City of Portland, Maine - Building or Use Permit Application
 389 Congress Street, 04101 Tel: (207) 874-8703, Fax: (207) 874-8716

Permit No: 09-0011	Issue Date:	CBL: 063 D026001
------------------------------	--------------------	----------------------------

Past Use: Single Family Home	Proposed Use: Single Family Home - enclose existing 5'5"x6'5" rear covered porch. After the fact permit	Permit Fee: \$50.00	Cost of Work: \$3,000.00	CEO District: 2
Proposed Project Description: enclose existing 5'5"x6'5" rear covered porch. After the fact permit. Deck.		FIRE DEPT: <input type="checkbox"/> Approved <input type="checkbox"/> Denied	INSPECTION: Use Group: Type	
		Signature:	Signature:	
PEDESTRIAN ACTIVITIES DISTRICT (P.A.D.)				
Action <input type="checkbox"/> Approved <input type="checkbox"/> Approved w/Condition <input type="checkbox"/> Denied				
		Signature:	Date:

South Elevation Interior

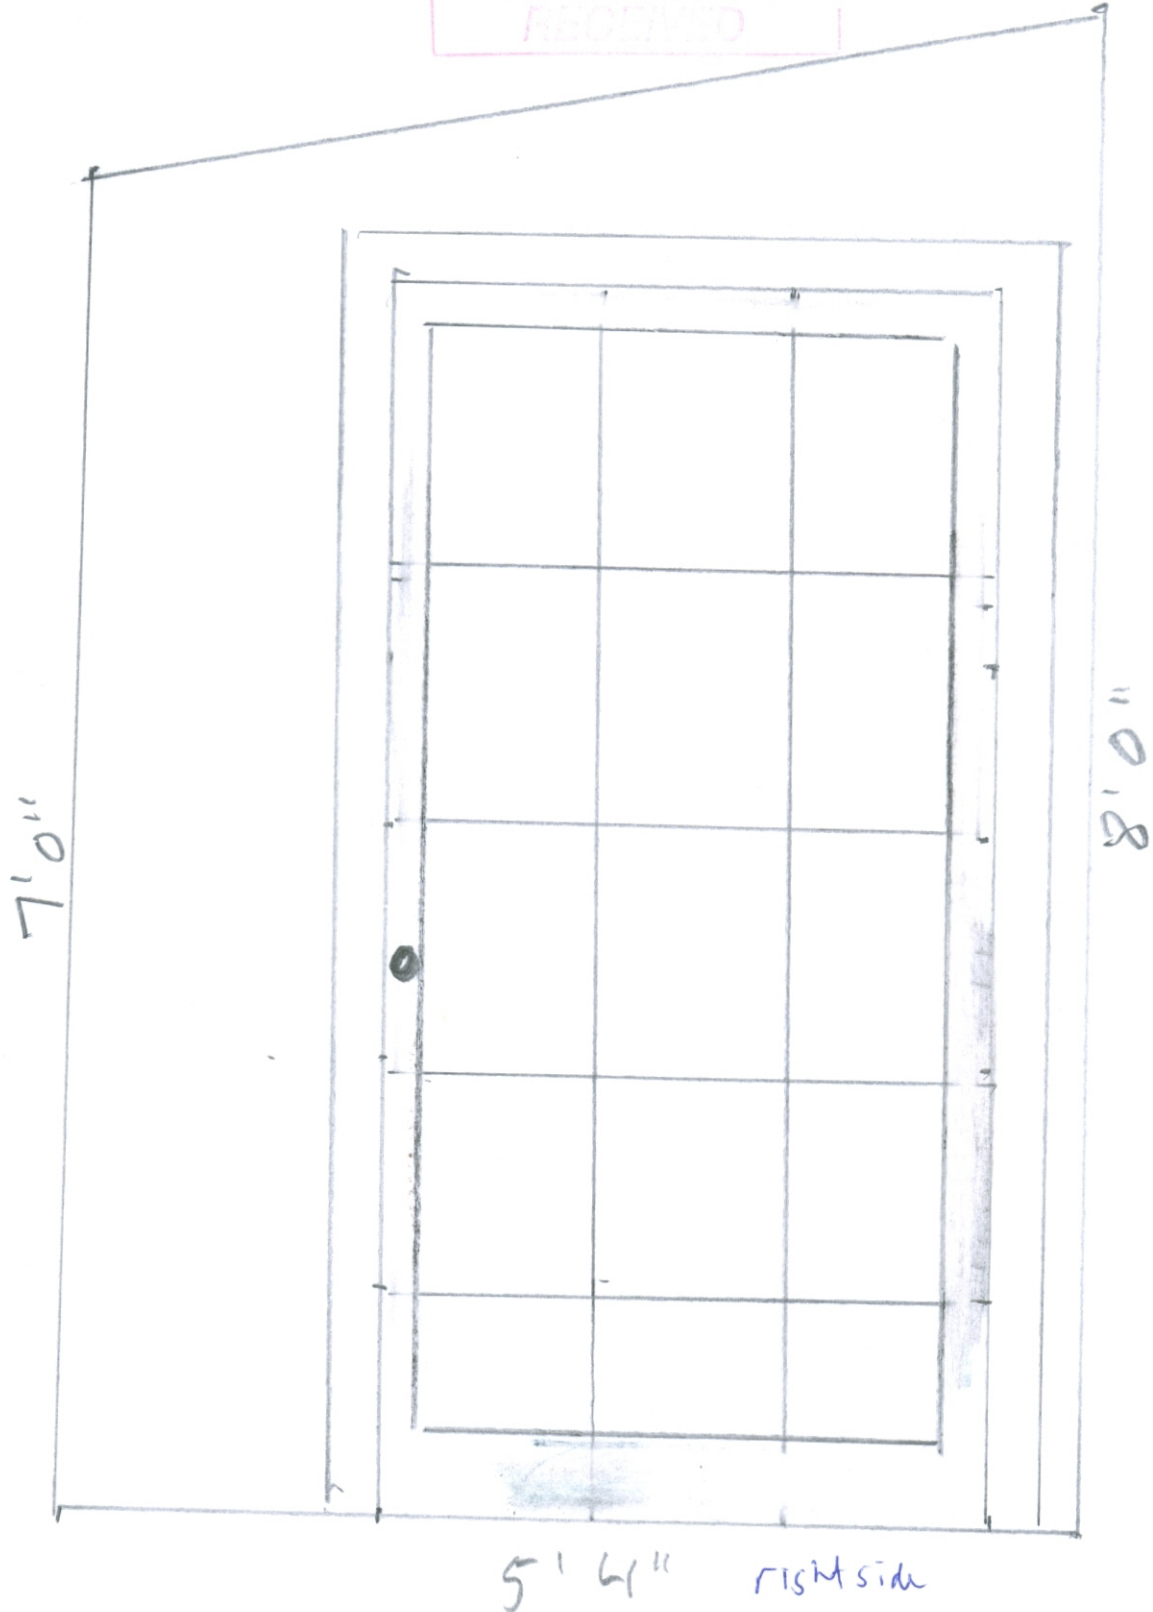
1/9/2009-amachado: Spoke to Denis O'Brien. Need pictures of what existed before & the majority of the mudroom needs to be glass (section 14-427).

1/22/2009-amachado: Denis brought in revised plans for the enclosed porch which includes more glass to meet section 14- 427. He could not find any pictures of the porch before he enclosed it. He is still trying to find some.
